Your Ref: ECH1065
Our Ref: BE/127/12/A
Please ask for:
Mr C Cronin

Town & Country Planning (Control of Advertisement) (England) Regulations 2007 (as amended)

Various non-illuminated & internally illuminated signage
Former LEC Site Shripney Way Bognor Regis

The Planning and Licensing Committee discussed the Sainsbury's Planning Application, BE/127/12/A at their meeting on the 18th December 2012. Please find their comment below:

Proposed Welcome Wall & Vinyl Details

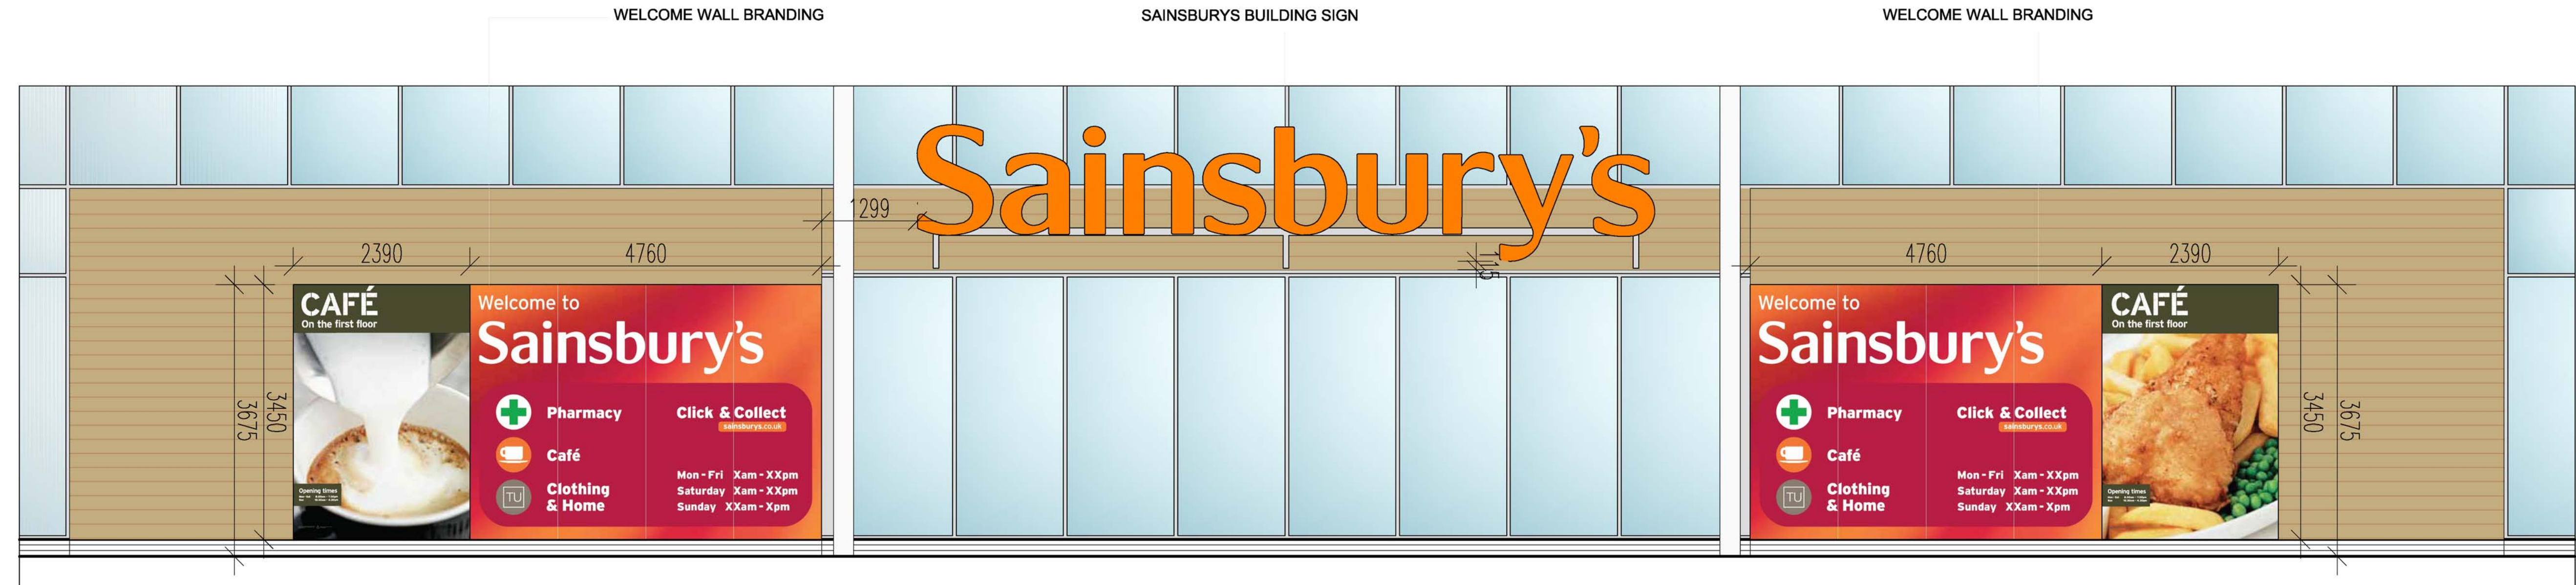
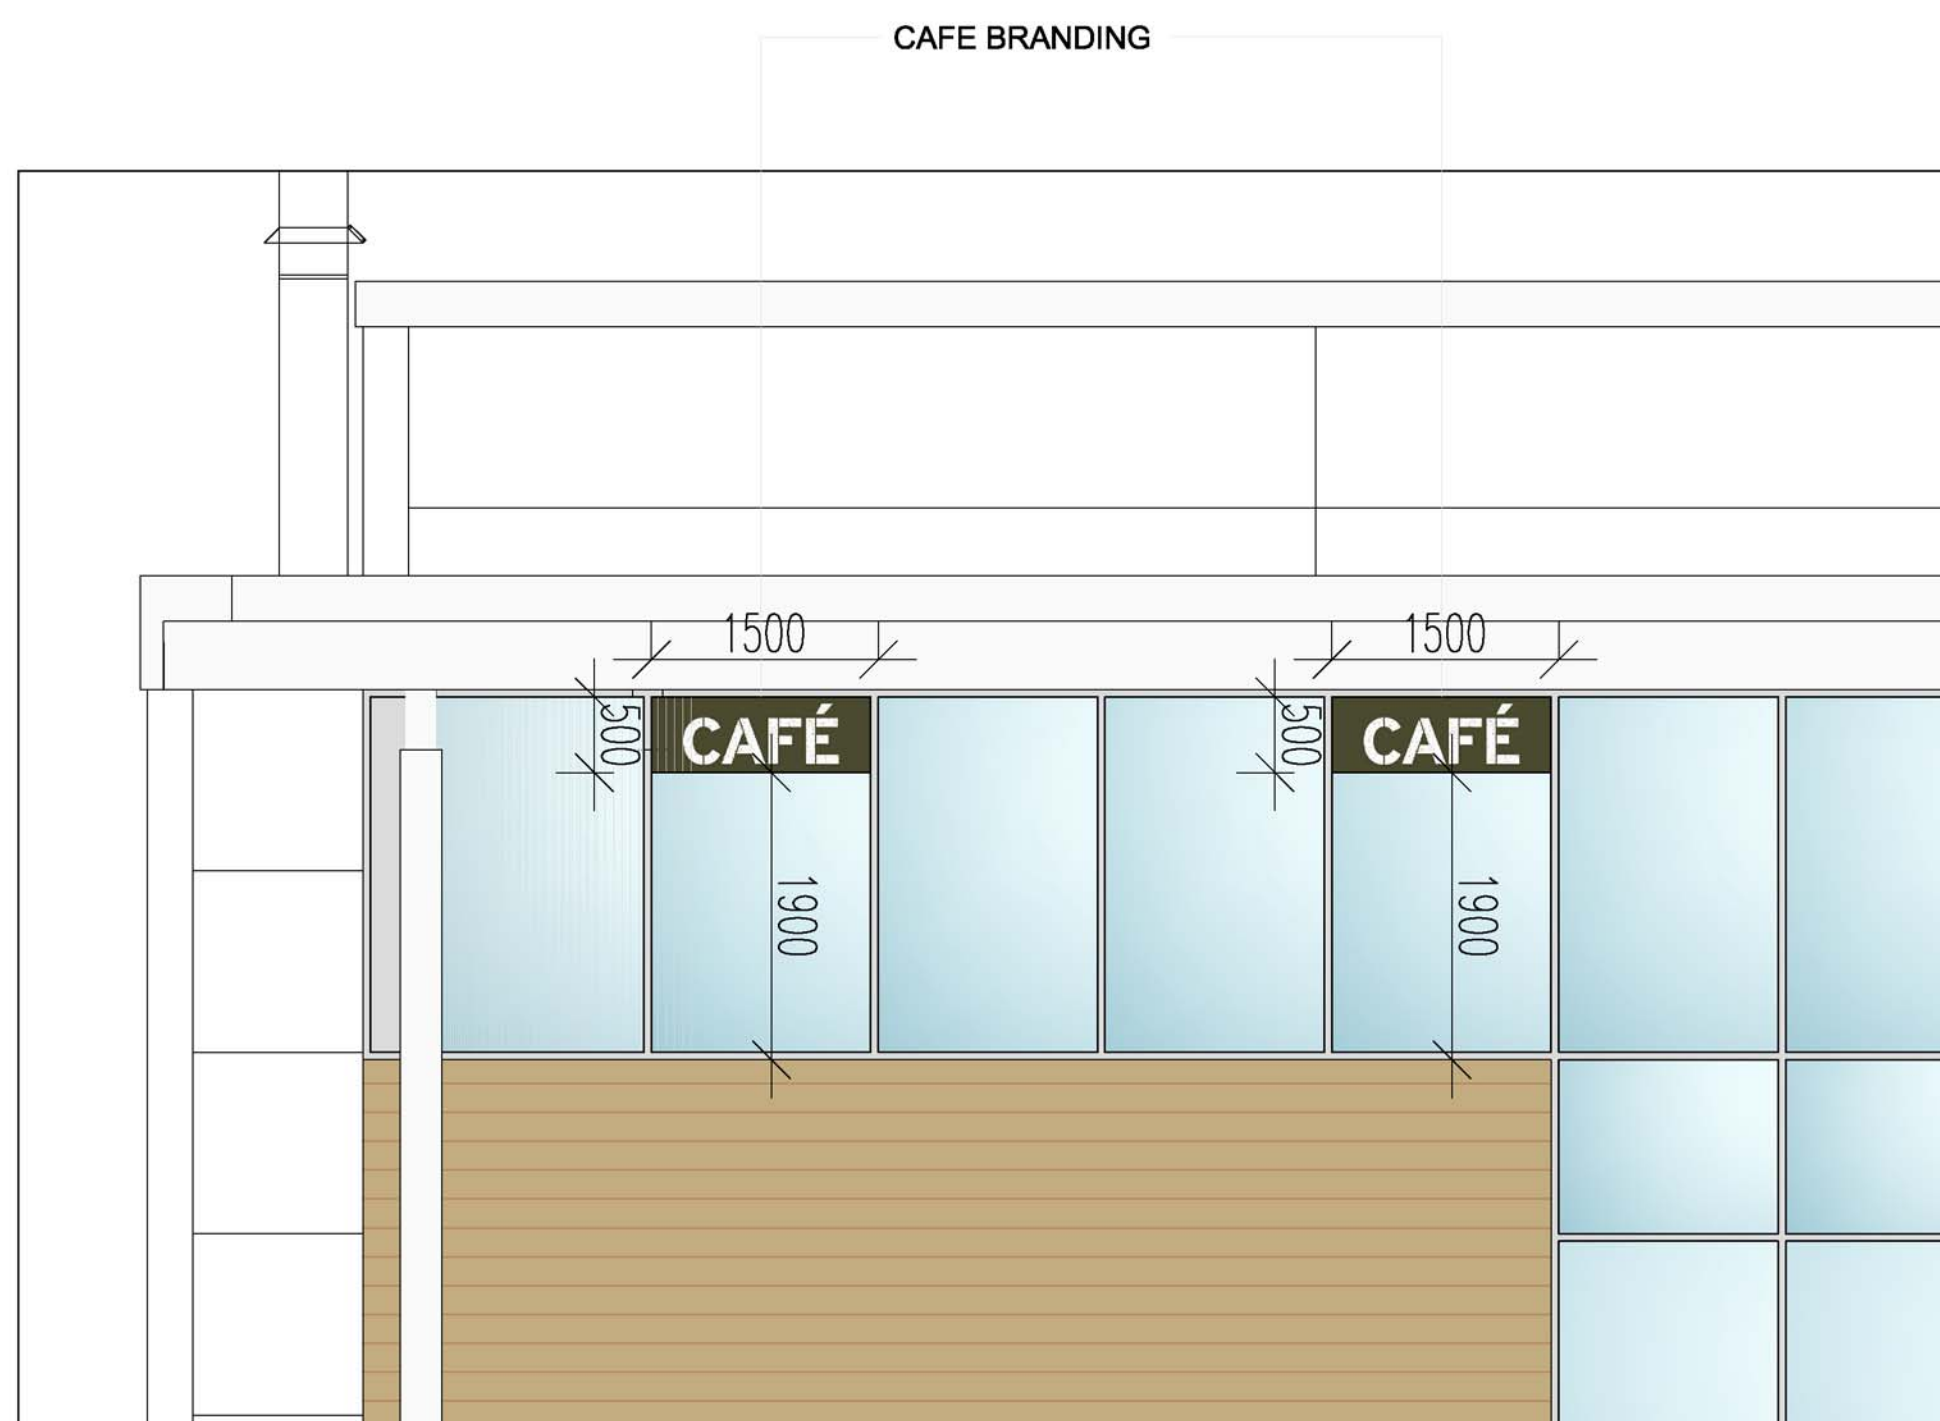
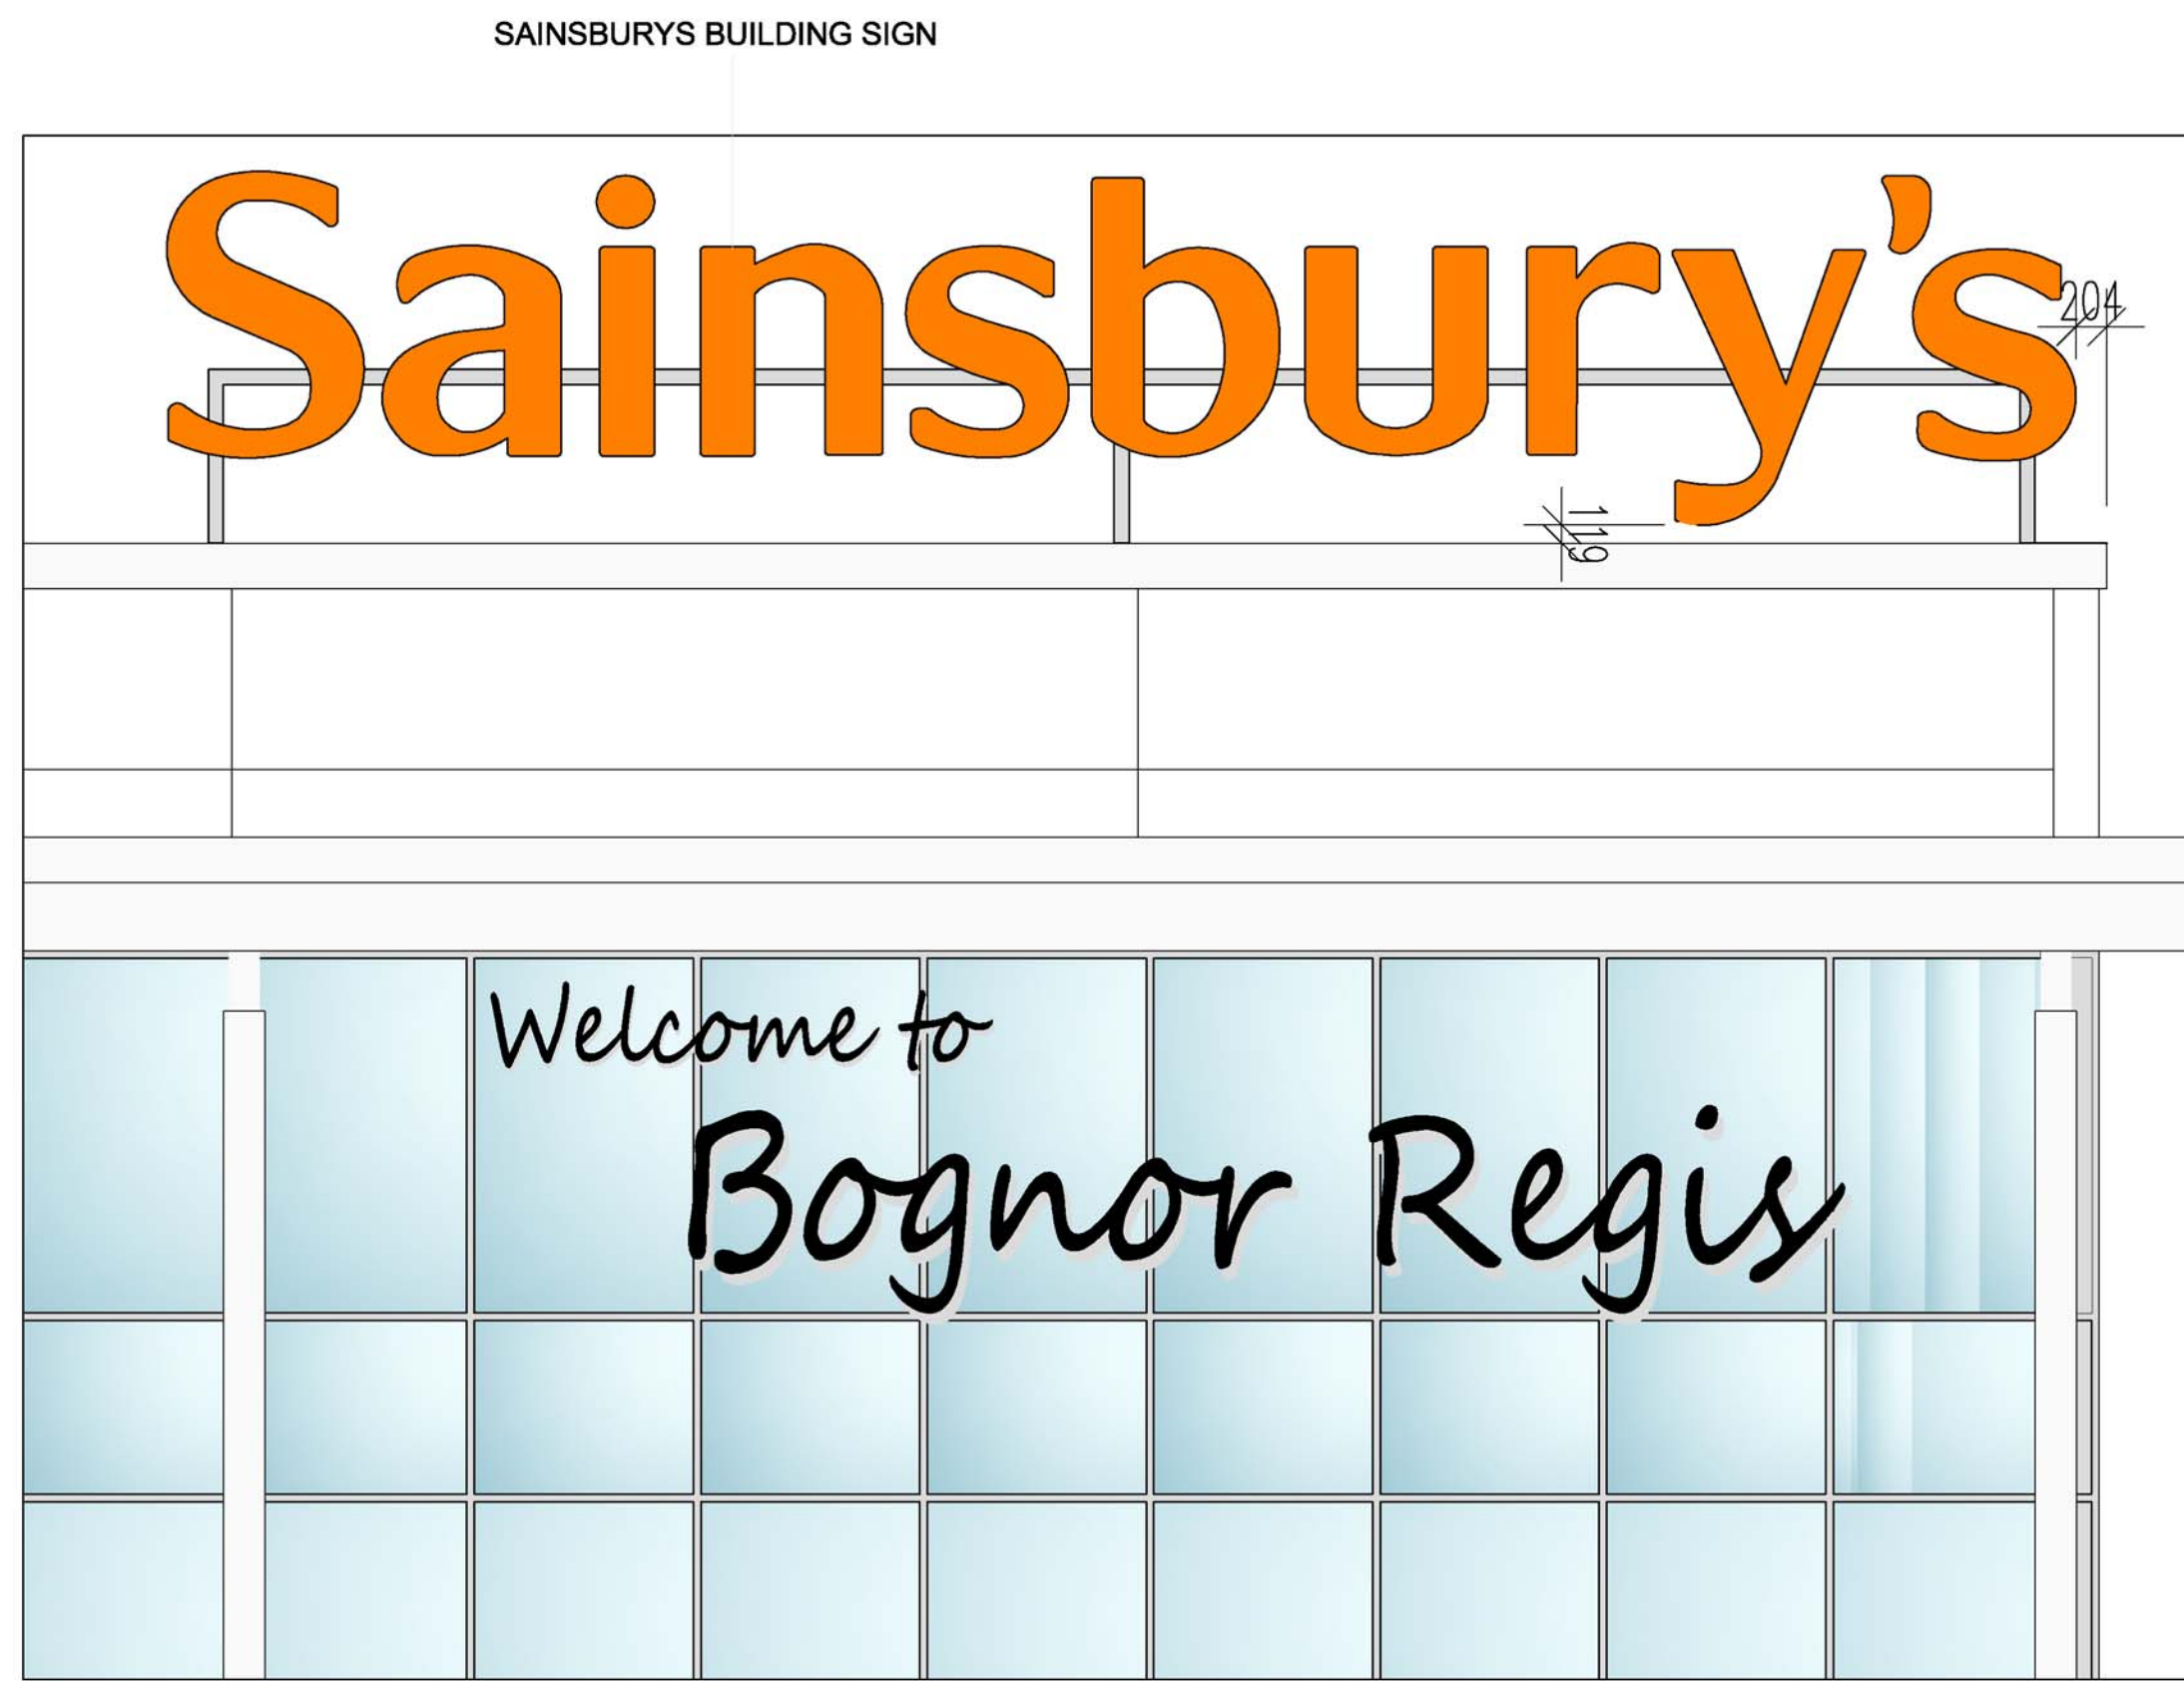
NO OBJECTION but the Committee expressed their disappointment that the 'Welcome to Bognor Regis' is not more prominent as had been previously promised
